**Planning Application Ref:** R/120/18/T

**Location:** 8 Elm Farm Cottages, Old Manor Road, Rustington

**Description of works:** Crown reduce 1No. Horse Chestnut tree by 1.5m to all sides and crown lift by 5m to the east side and 4m to the west

Horse
CHESNUT
TREE T6

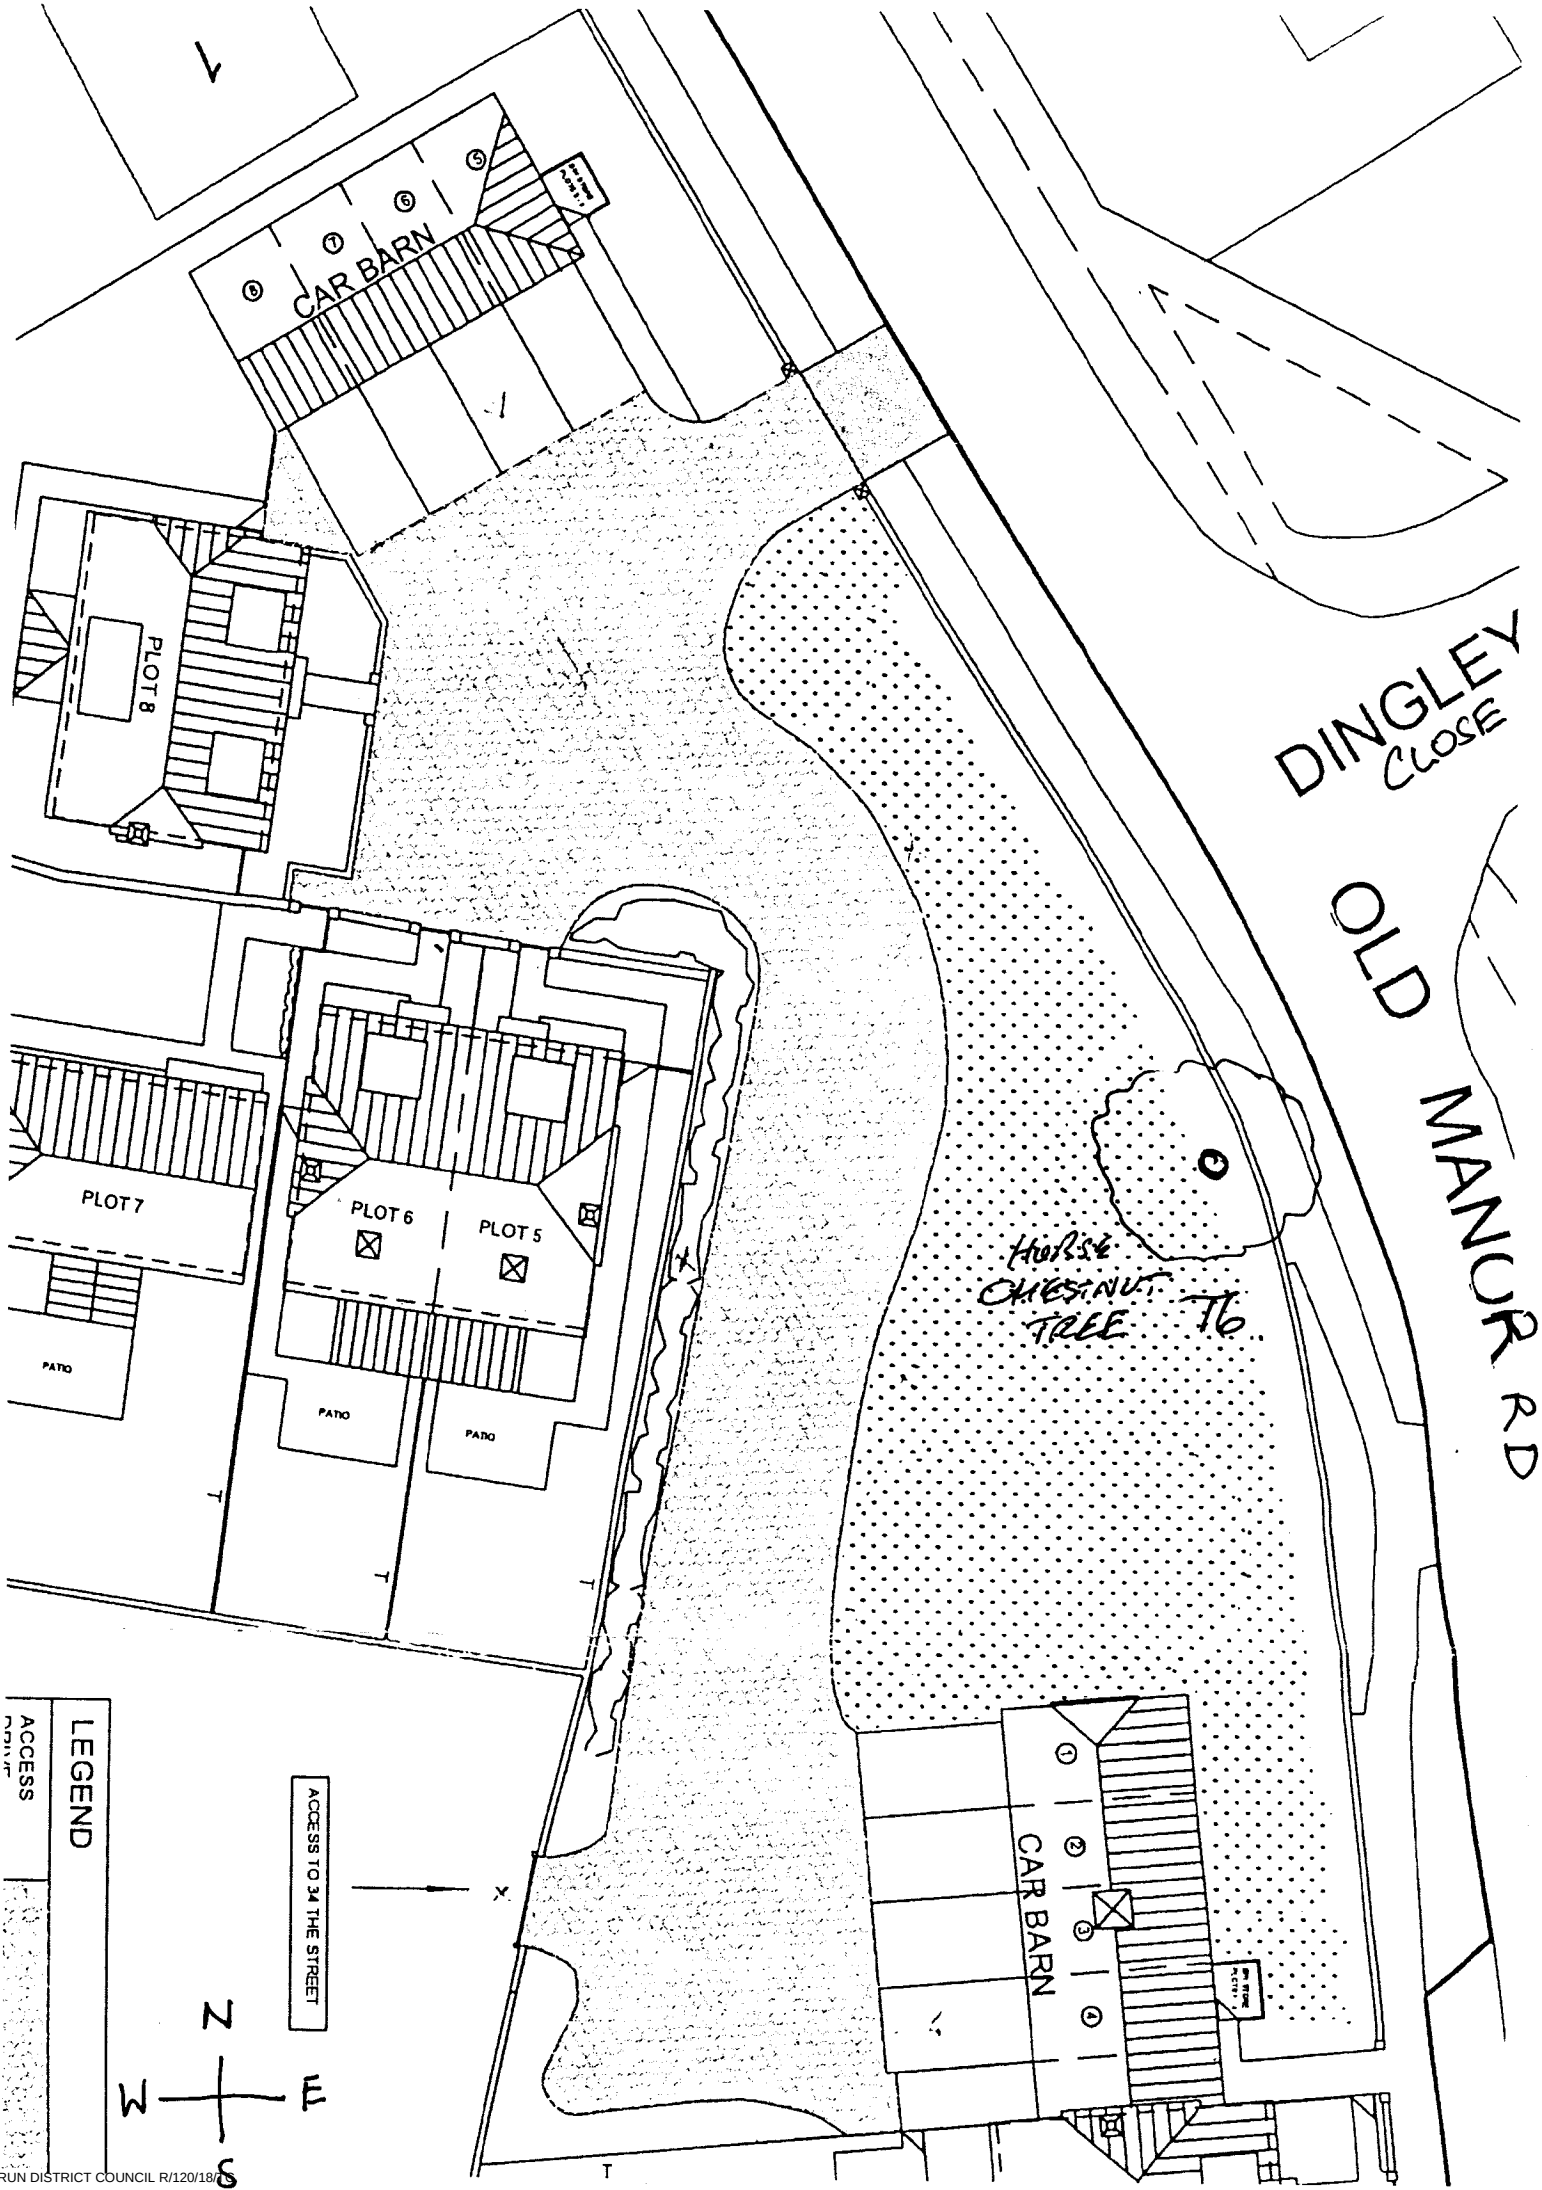
- It has an attractive crown profile, with little evidence of any significant past pruning. Overall it displays good form and typical of the species.
- Low branches are beginning to obstruct safe passage for public highway users.
- A prominent ornamental tree, highly visible from the public highway and surrounding residential properties.
- Outwardly and from a distance this tree appears to be in good health and structurally sound, with high growth potential.

- There is no arboricultural justification for the proposed crown reduction work.
- There are valid reasons for the proposed crown lifting to 5m over the carriageway. Crown lifting proposed for other aspects exceeds that which is necessary or desirable.
- The tree is a significant feature in the street scene and appears to be in adequately sound and healthy condition. The tree surgery proposed in the application would result in excessive reduction of the tree's landscape impact and undue detriment to the visual amenities of the locality.

- I recommend **REFUSAL** for this application.

- If the applicant were to re-submit with the following work specification, I could recommend APPROVAL, subject to the conditions beneath:
  - Crown lift on East aspect to achieve 5metres clearance above carriageway.
  - Crown lift to a maximum of 2.5metres on all other aspects.
